To: Lisa Gish
Engineering Inspector I
El Paso County Department of Public Works

From: Eric Gunderson, P.E.,
Kimley-Horn and Associates, Inc.

Date: April 6, 2023

Subject: Widefield Parks and Recreation – Recreation Center – Pond Outlet Structure

OUTLET STRUCTURE PROFILE DETAIL
N.T.S.

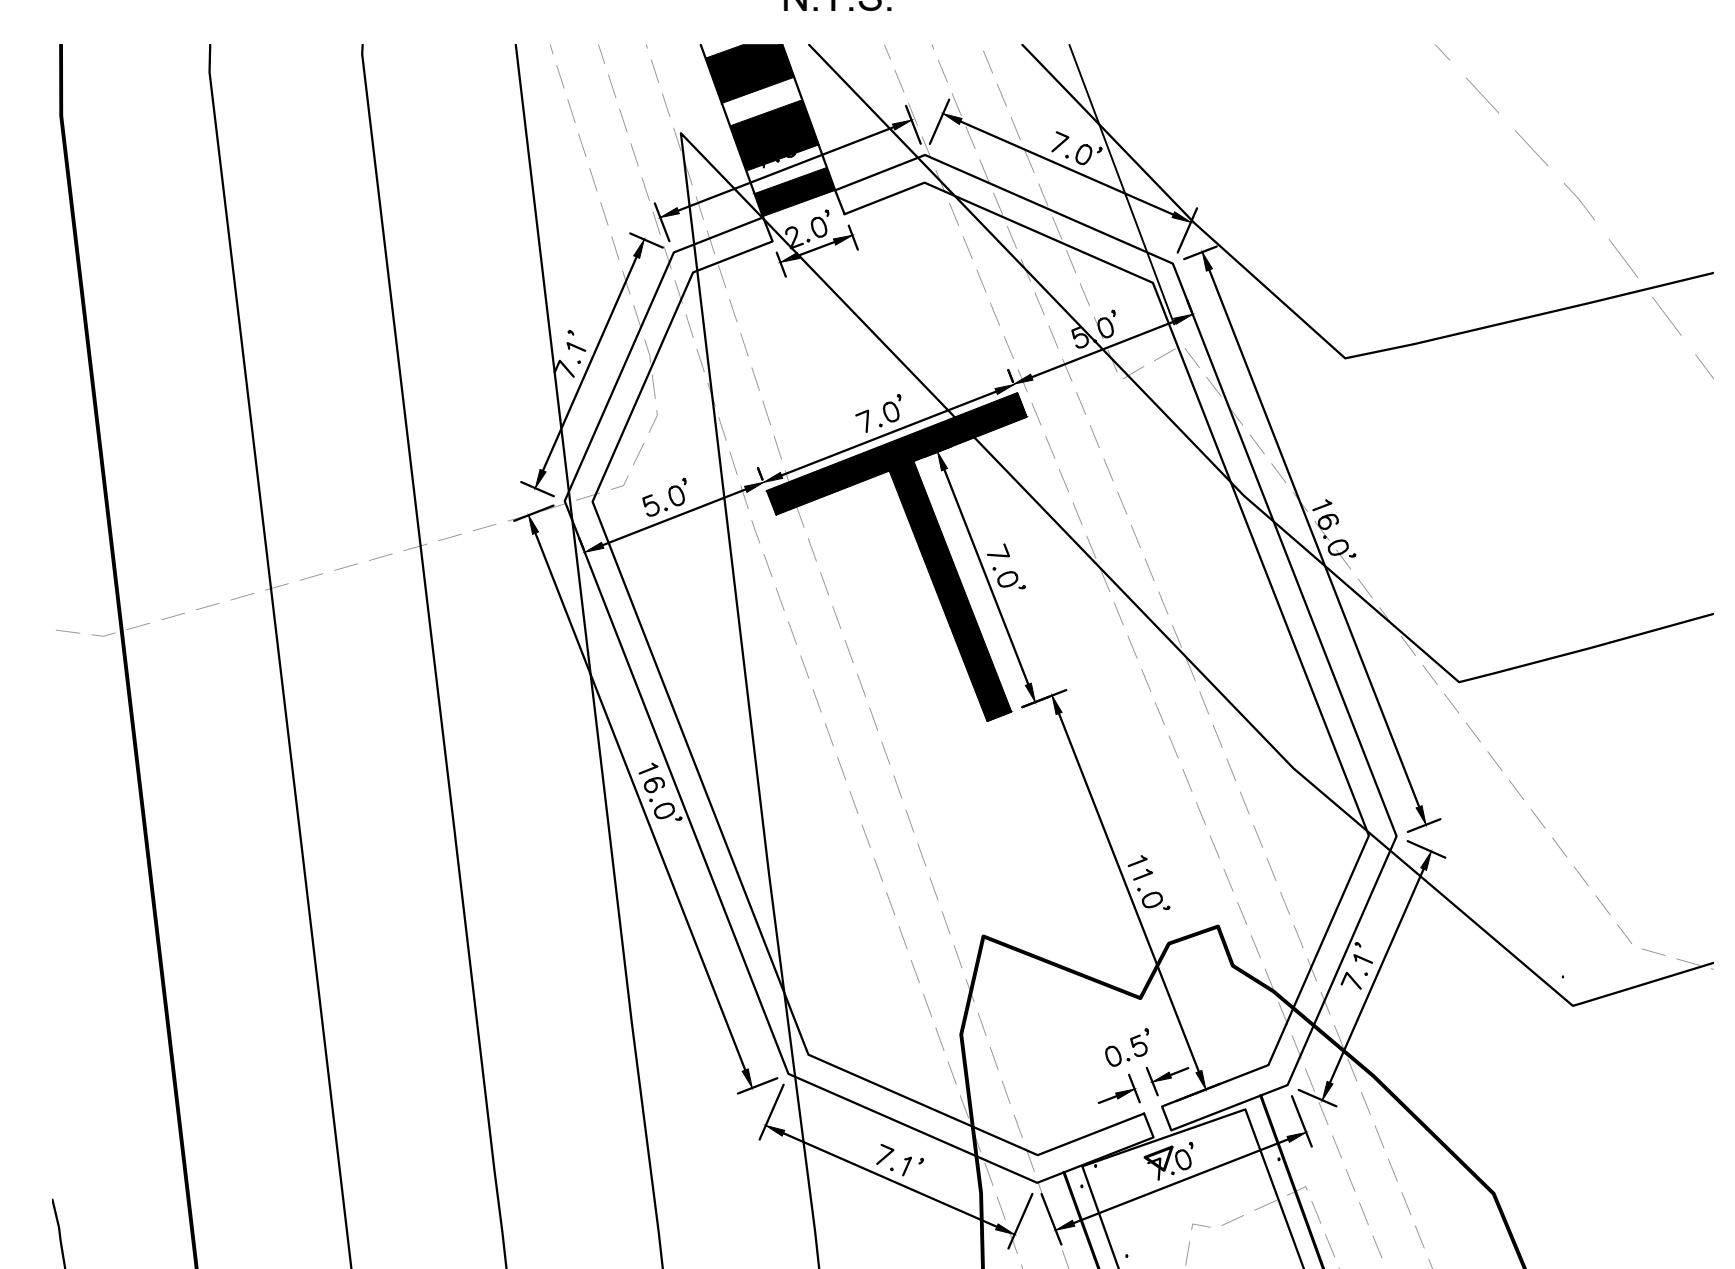
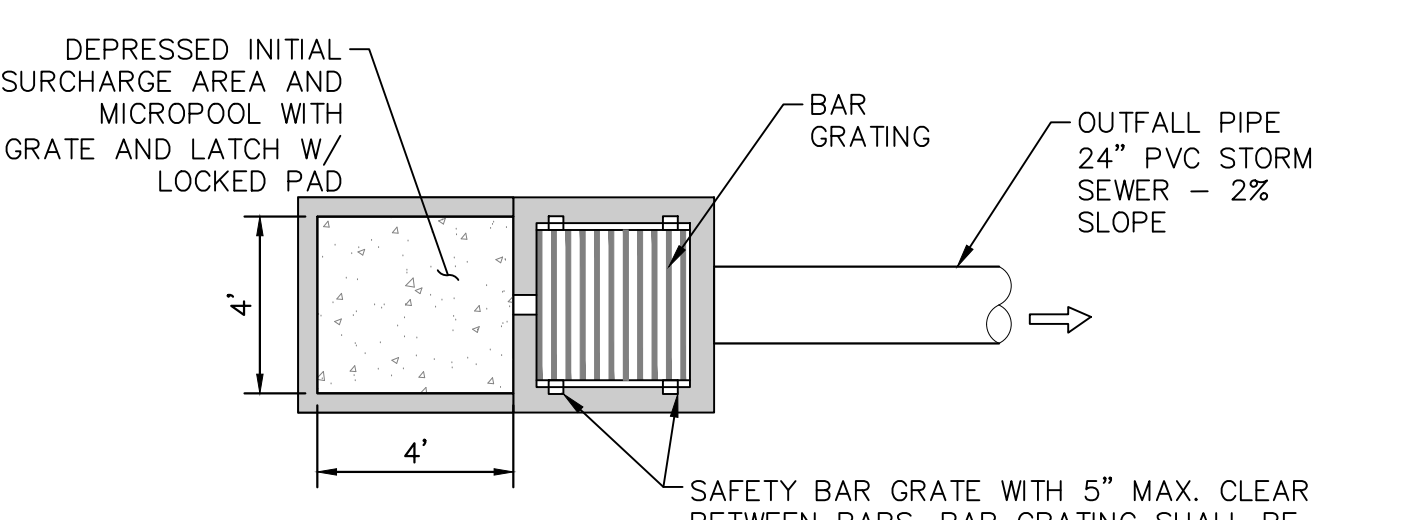
Based upon an email received by Kimley-Horn from Lisa Gish dated April 4, 2023 4:09PM, it is understood the proposed outlet structure in the extended detention basin at the subject site has been constructed differently than the approved plans dated 2/28/23. The approved plans call for a 5'x5' Type C CDOT structure with 4:1 sideslope/grate. Based upon the referenced email from the County, it is understood the structure was installed at 4'x4' and was installed with a flat top instead of the 4:1 sloping grate.

Attached is a markup of the approved pond plans showing the as constructed condition based upon the information above. Kimley-Horn redesigned the outlet structure using this information and the MHFD analysis has been included in this memo, following the plan markup.

Based upon the information above and analysis performed herein and the adjustment to the restrictor plate, the change in size and slope of the outlet structure is acceptable to the engineer of record.

100-YEAR FLOW RESTRICTOR DETAIL
N.T.S.

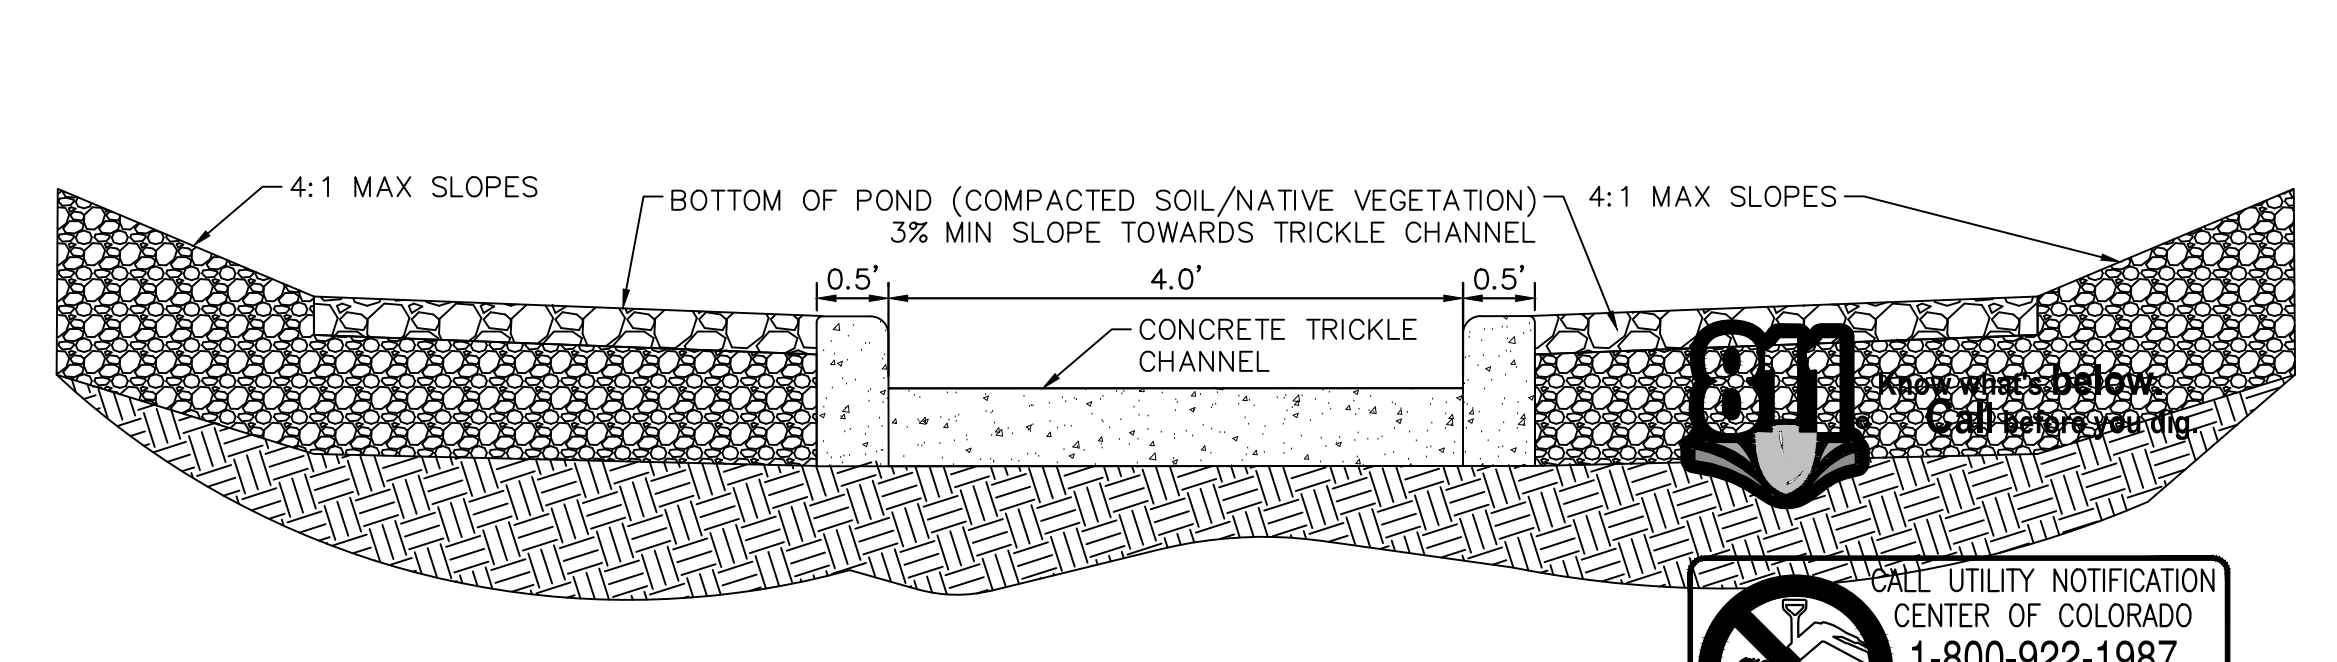
Kimley-Horn proposes lowering the restrictor plate on the outlet pipe 6" for a total of 12" of clearance as noted. This will maintain the appropriate pre-development vs. post development flow ratios and drain times to be in compliance with the approved final drainage report for the project.
